**WELWYN HATFIELD BOROUGH COUNCIL
EXECUTIVE DIRECTOR - PLANNING, PUBLIC PROTECTION AND GOVERNANCE**

Application No: 6/2018/0801/HOUSE
Location: 69 Northaw Road East Cuffley Potters Bar EN6 4LY
Proposal: Erection of a first floor extension and loft extension to include alterations to the roof and a hip to gable conversion and raising the ridge height.
Officer: Mr Richard Sakyi

Recommendation: Refused

Drawing N°: ELA/66 Rev: 02

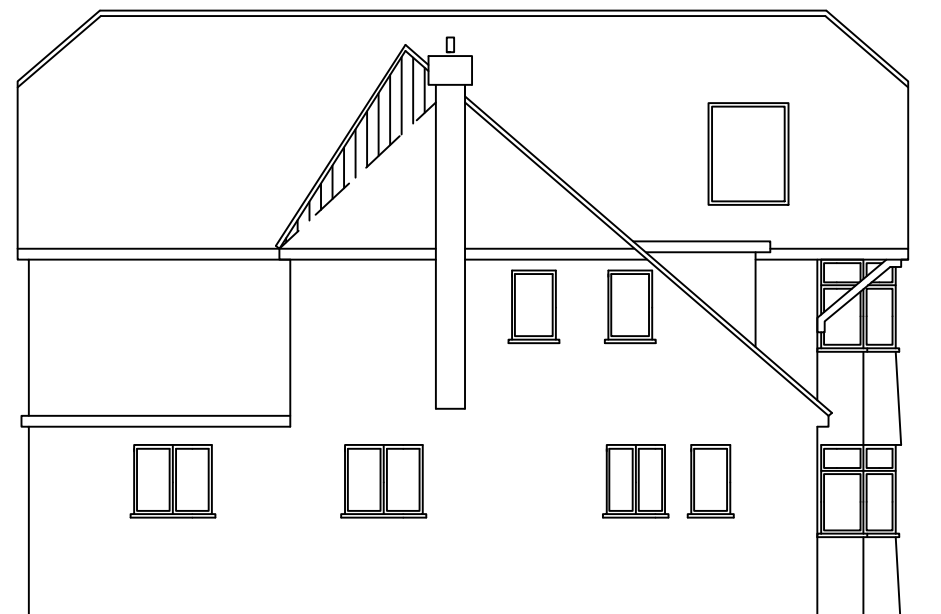
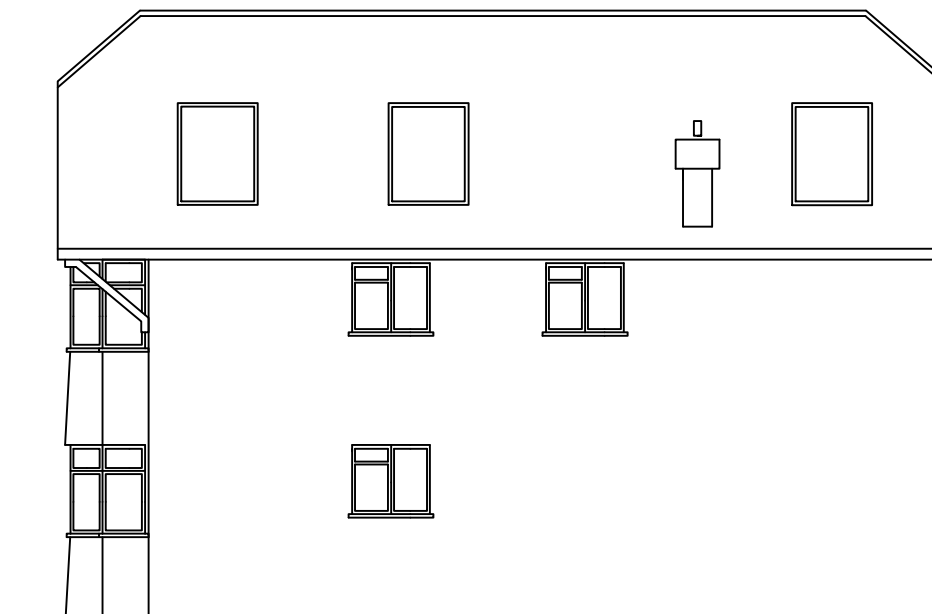
<p>proposal (first floor side extension) by reason of size, scale and design fails to comply with Policy D1 and Policy D2 of the adopted Welwyn Hatfield Local Plan 2005 and there are no material considerations in this case put forward by the applicant which outweigh the harmful impact identified above.</p> <p>The overall impact of the development in its current form would fail to harmonise with the existing dwelling and the immediate area. Furthermore the overall scale, form and design is considered to detract from the character of the street-scene to an unreasonable extent, contrary to Policies D1 and D2 of the Welwyn Hatfield District Plan 2005</p>
Impact on neighbours	<p>It is considered in regards to loss of privacy, outlook and overshadowing, any harm caused will be limited due to the siting of the proposed extensions relative to the adjoining and neighbouring properties. Furthermore, it is considered that there would be no undue loss of light to the neighbouring properties due to the orientation of the dwellinghouse.</p>

1. The proposed extension would, by reason of the design, bulk and massing, result in an unsympathetic addition that would fail to respect and relate to the character and appearance of the original dwelling. As a result of the size and design of the extension, in particular the gable front element, it would present a bulky and dominant feature, which would fail to be subordinate in scale and form to the host property. It would represent a prominent addition to the street scene and would cause harm to the character and appearance of the area as a result. The proposal therefore fails to result in a high quality of design and is contrary to Policies D1, D2 and GBSP2 of the adopted Welwyn Hatfield District Plan 2005, the Supplementary Design Guidance 2005 and Section 7 of the National Planning Policy Framework.
